Your Ref: SSD 9274  
Our Ref: D18/5317  
DA18042312781 GB

20 December 2018

**Part 3A/State Significant Development Application - Samuel Gilbert Public School - Corner Ridgecrop Drive and Gilbert Road Castle Hill**

Figure 10 - Asset Protection Zone Plan

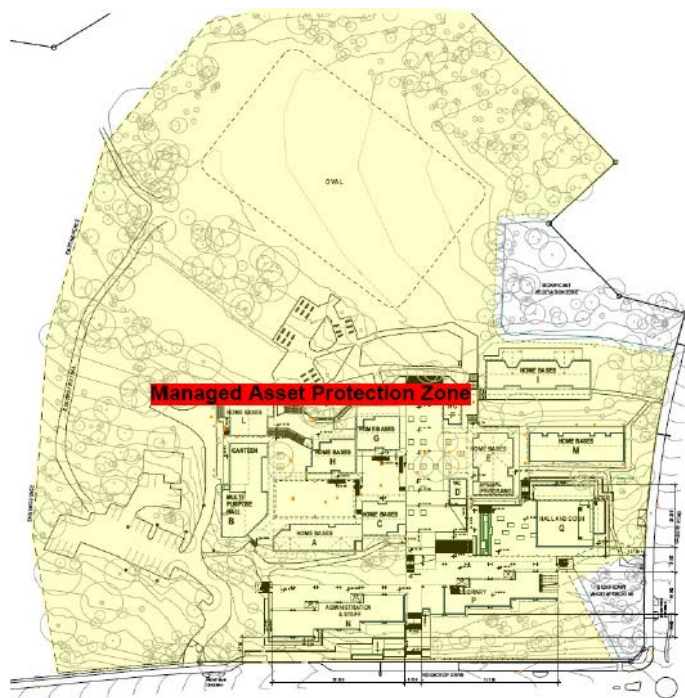
1. At the commencement of building works and in perpetuity, the enclosed area of the school grounds bounded by the existing fence, (excluding the two small areas of EEC Turpentine-Ironbark Forest labelled as significant Vegetation zone) shall be managed as an inner protection area (IPA) as outlined within Appendices 2 & 5 of 'Planning for Bush Fire Protection 2006' and the NSW Rural Fire Service's document 'Standards for asset protection zones'.
2. The provision of water, electricity and gas supplies shall comply with sections 4.1.3 and 4.2.7 of 'Planning for Bush Fire Protection 2006'.
3. A Bush Fire Emergency Management and Evacuation Plan shall be prepared for the school or the existing plan amended to include the new buildings. The Plan shall be consistent with 'Development Planning – A Guide to Developing a Bush Fire Emergency Management and Evacuation Plan December 2014'.
